KITITAS COUNTY

MEMORANDUM

TO: All Staff
FROM: Public Works Plan Review Team
DATE: June 1, 2022
SUBJECT: BL-22-00014 Maultsby

The Public Works Department has reviewed the Request for Boundary Line Adjustment Application. The applicant needs to be aware of the following:

RECORD OF SURVEY
 A PORTION OF THE N 1/2 OF SECTION 8,
 TOWNSHIP 18 NORTH, RANGE 18 EAST, W.M.,
 KITTITAS COUNTY, WASHINGTON

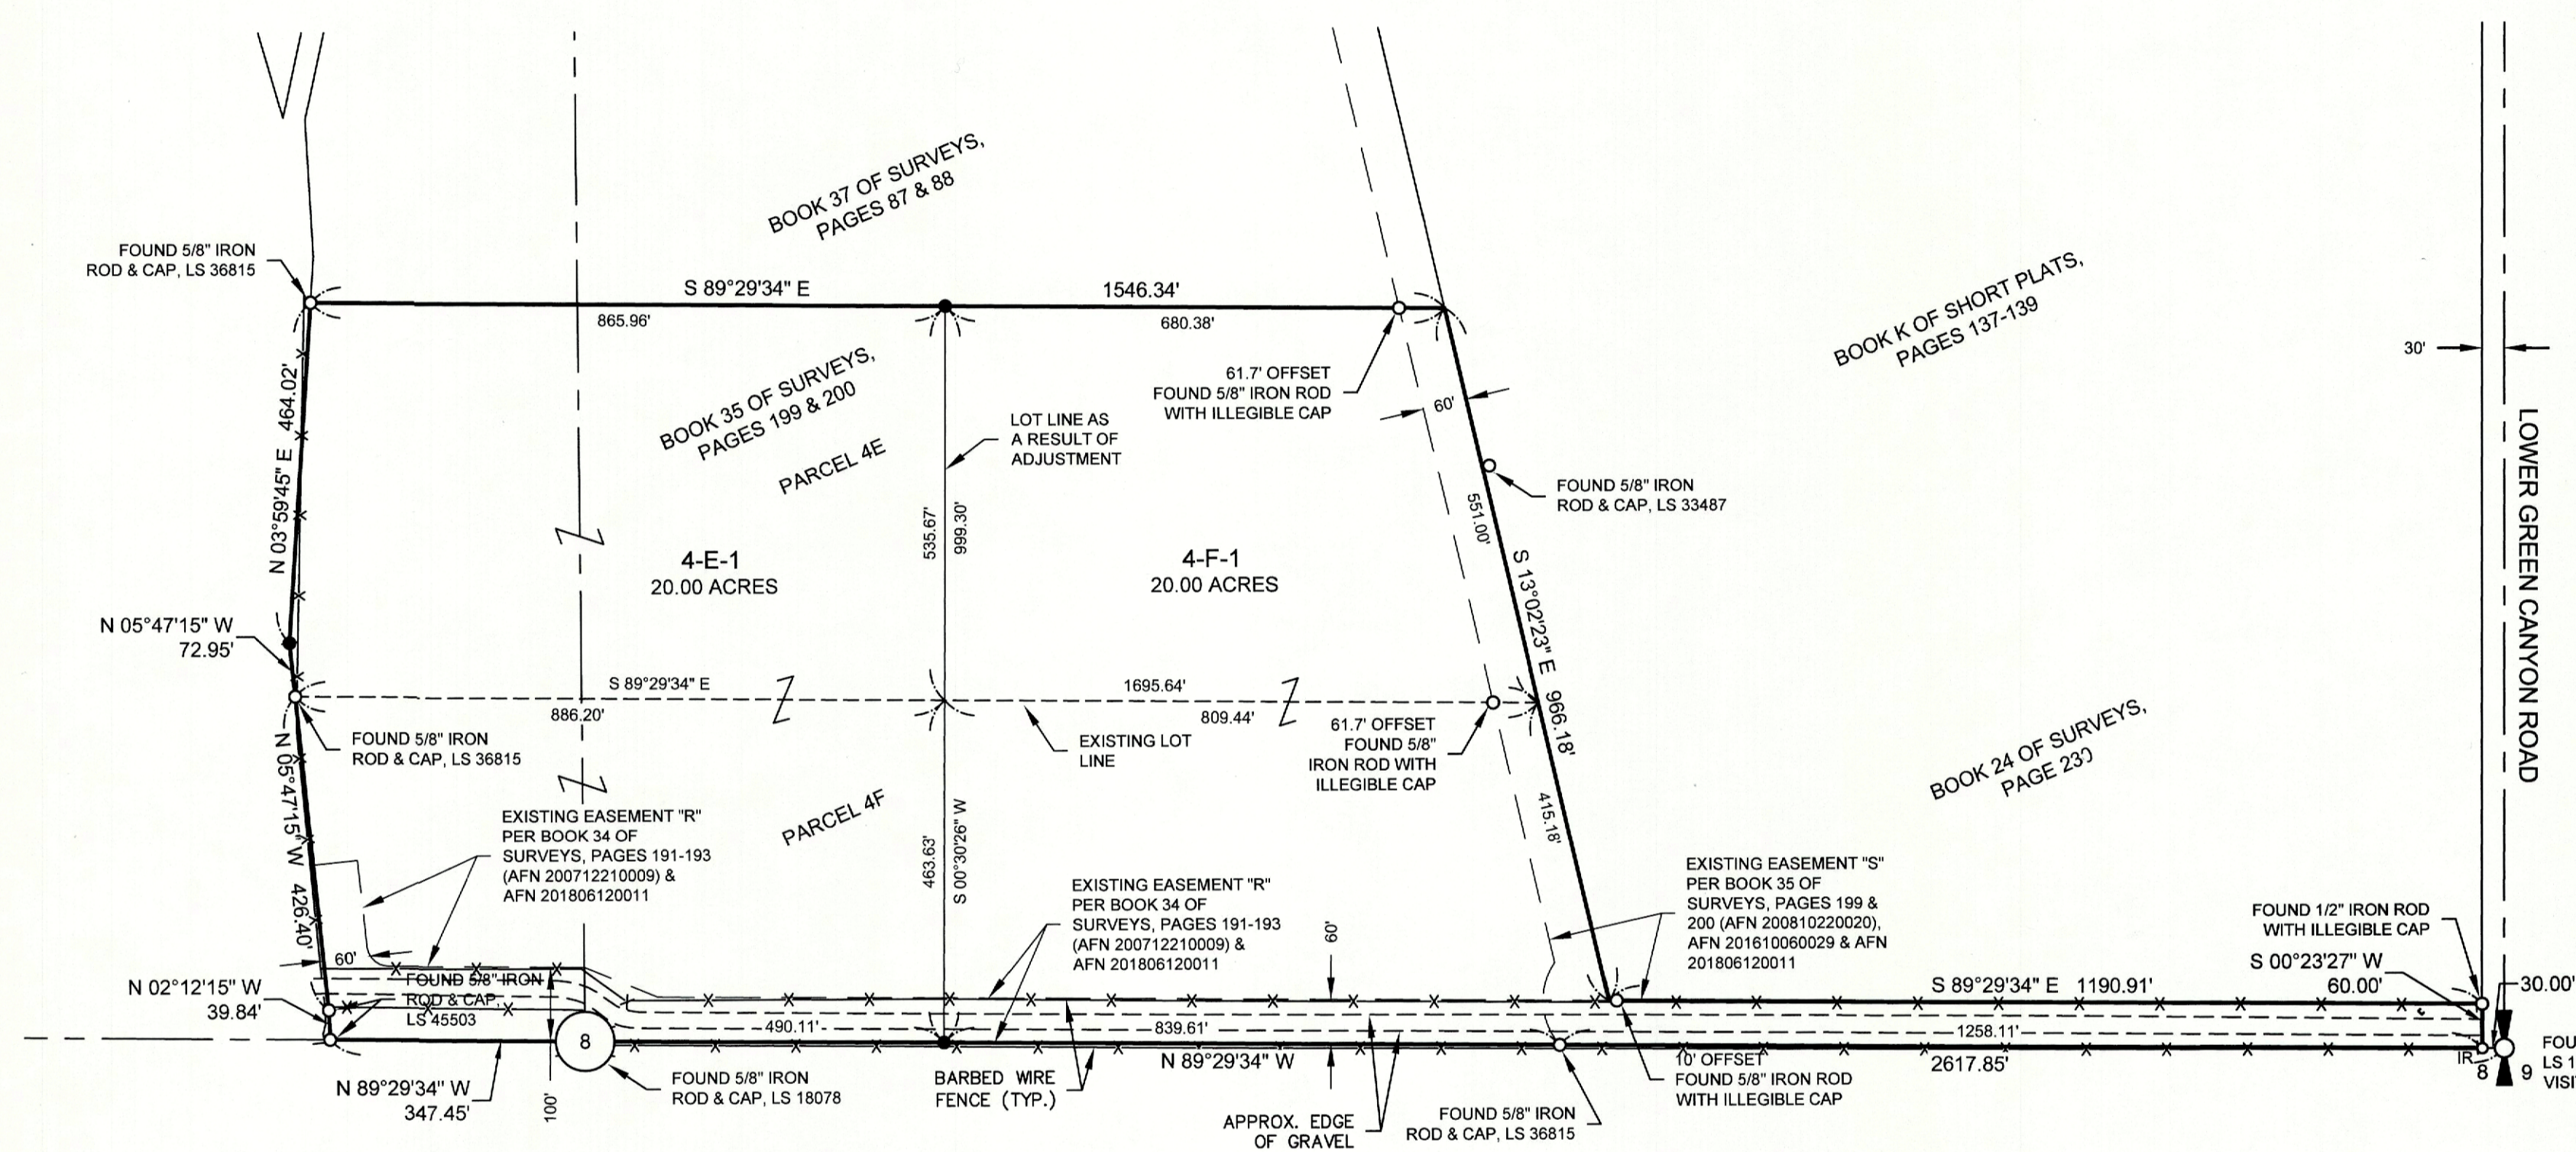
1. Correct multiple instances of text being obscured by crossing linework. (RCW 58.09.050(4)), (WAC:332-130-050(1)(d)(i)) and (WAC:332-130-050(1)(d)(ii))
2. Show offset distance from Westernmost boundary to fence encroachments.
Show offset distance from Westernmost boundary to fence encroachments.
3. Roadways must show name, width, underlying ownership, easement or right of way and surface type.
4. Existing easements must show type of easement (access/ utility/ irrigation) as well as the identified recording number and width.
5. Legend may need to be updated with line type for fence.
